WEST SUSSEX COUNTY COUNCIL CONSULTATION

TO:	Arun District Council FAO: Simon Davis
FROM:	WSCC - Highways Authority
DATE:	19 June 2020
LOCATION:	The Beach Hotel, former Mud Club & 2-4 Waterloo Square Bognor Regis PO21 1SU
SUBJECT:	BR/282/19 Redevelopment into 49 No apartments consisting of 24 No 1 & 25 No 2 bed apartments & 2 No commercial units (A3 Restaurant & Cafe). This application affects the character & appearance of The Steyne, Bognor Regis Conservation Area & may affect the setting of a listed building. More information received.
DATE OF SITE VISIT:	29 March 2020
RECOMMENDATION:	No Objection

Drawing No.	Rev.
2020-6153-002	B

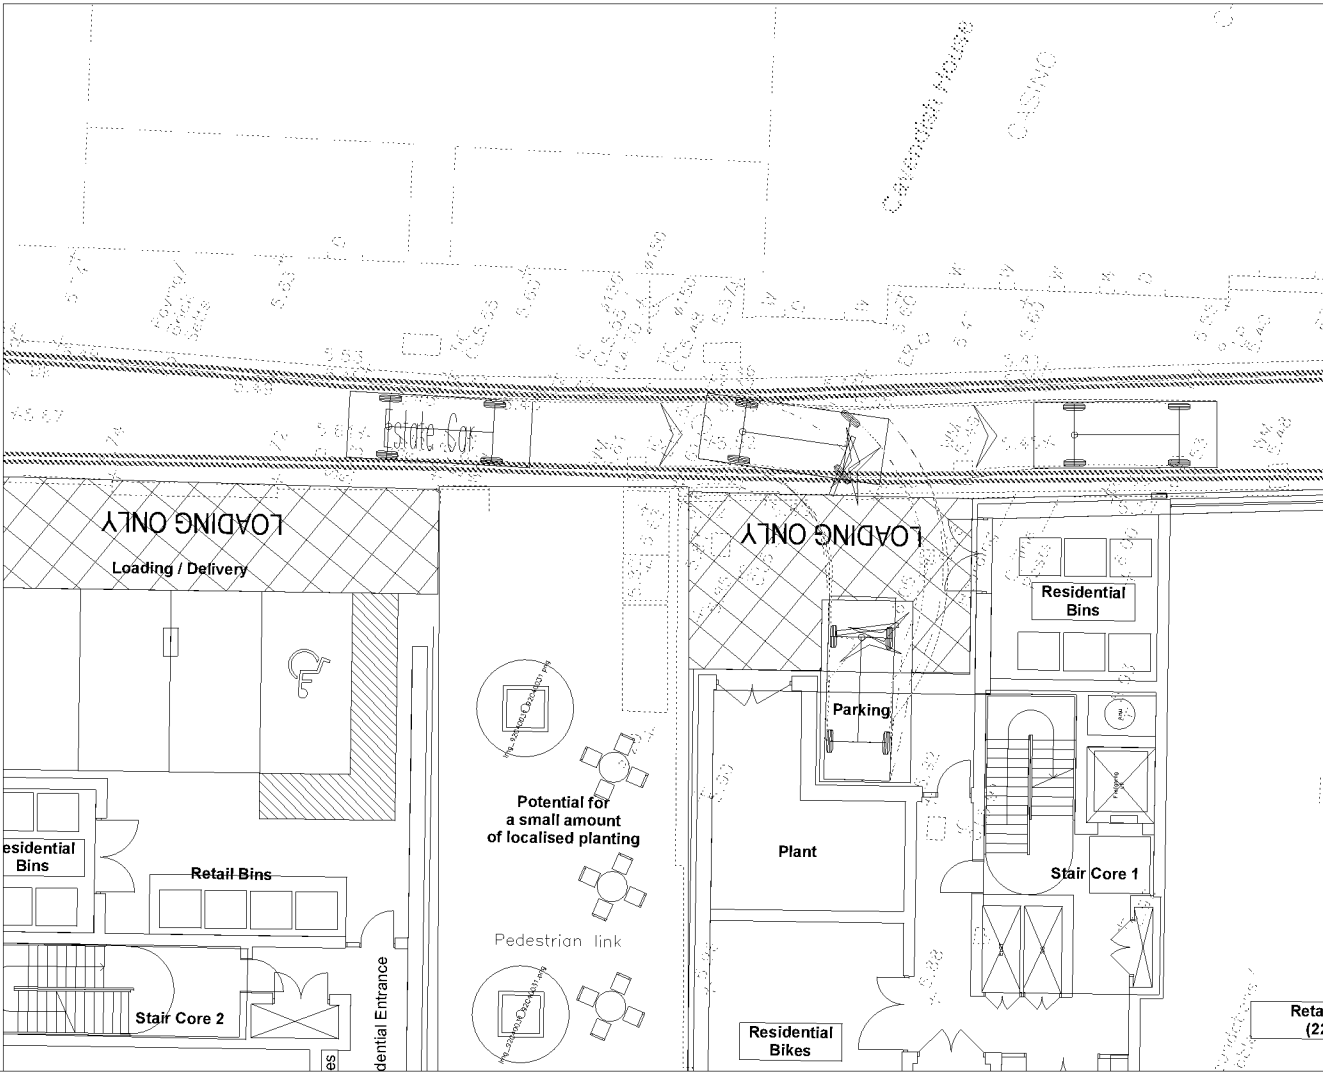
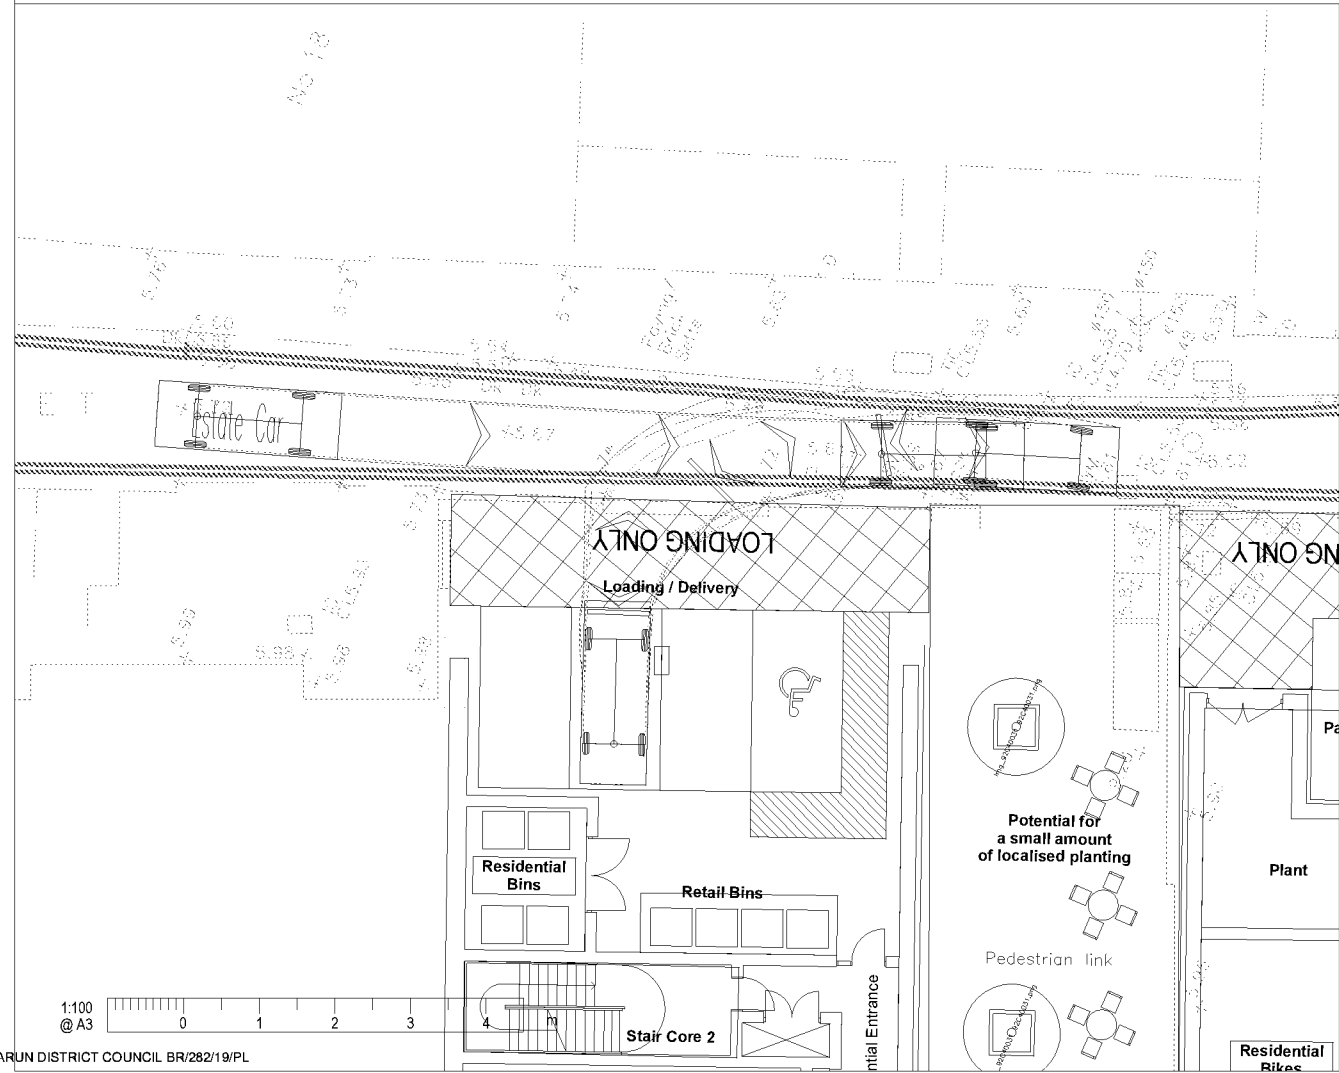
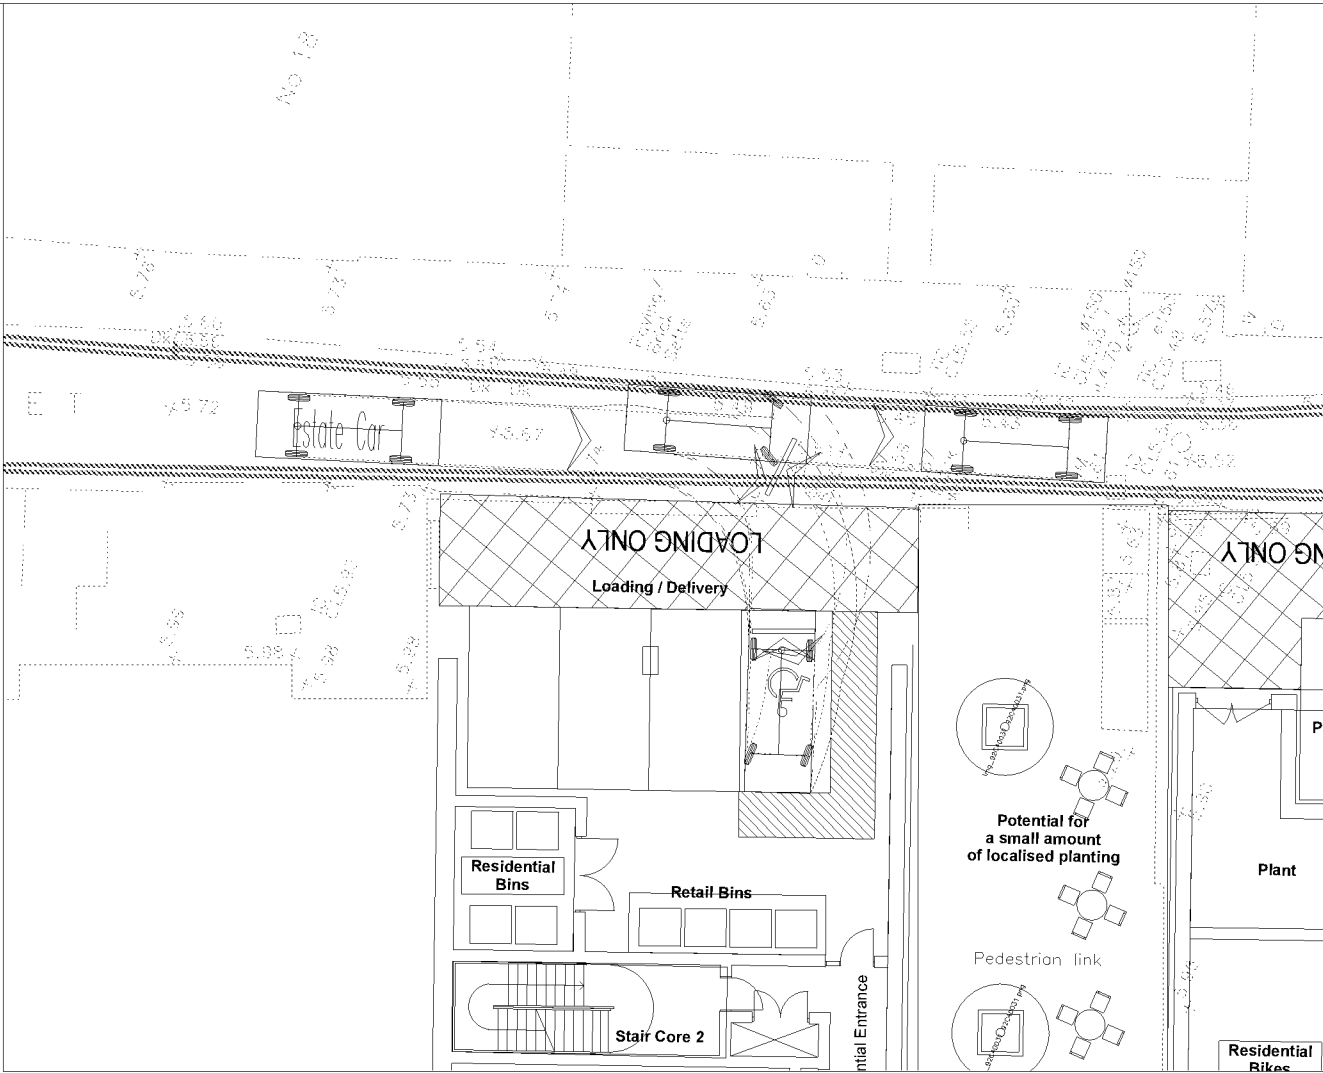
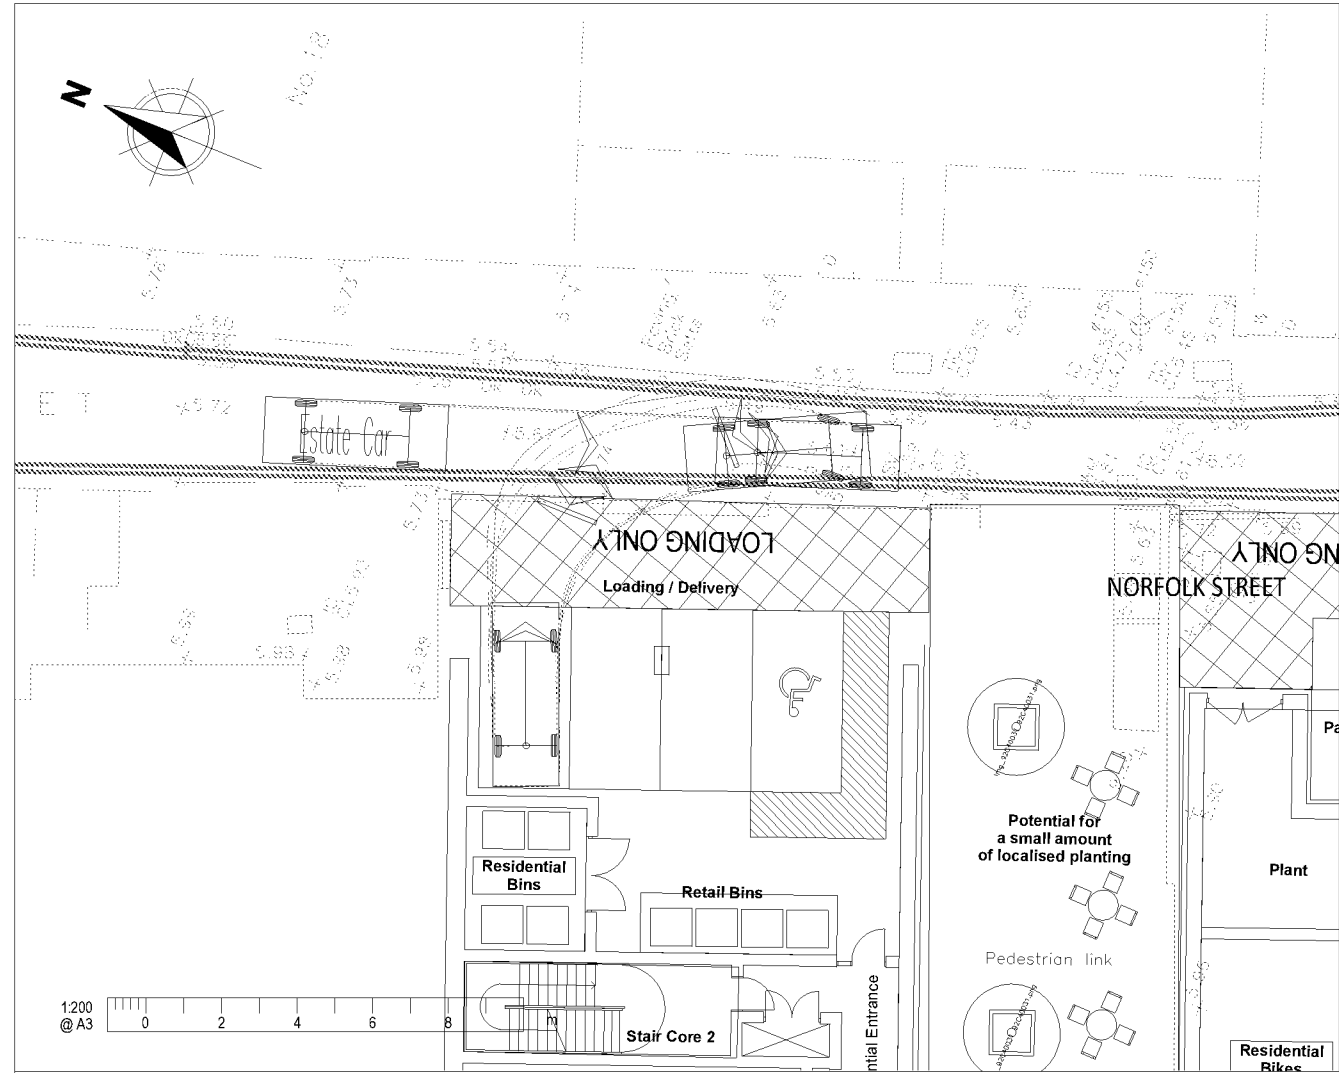
Swept path tracking plans show that the car parking spaces and loading bays will be a workable arrangement with manoeuvring to and from the one-way Norfolk Street. Deliveries can access and egress the loading bay areas as shown. Refuse collection is anticipated to be as per the existing arrangements for neighbouring properties. The panel van is shown manoeuvring through Norfolk Street from its junction with High Street. This manoeuvre shows a slight overhang to the adjacent footway however considering the anticipated low frequency and the fact this is an existing scenario for neighbouring properties, the LHA does not consider this would result in a 'severe' detrimental impact as per paragraph 109 of the National Planning Policy Framework.
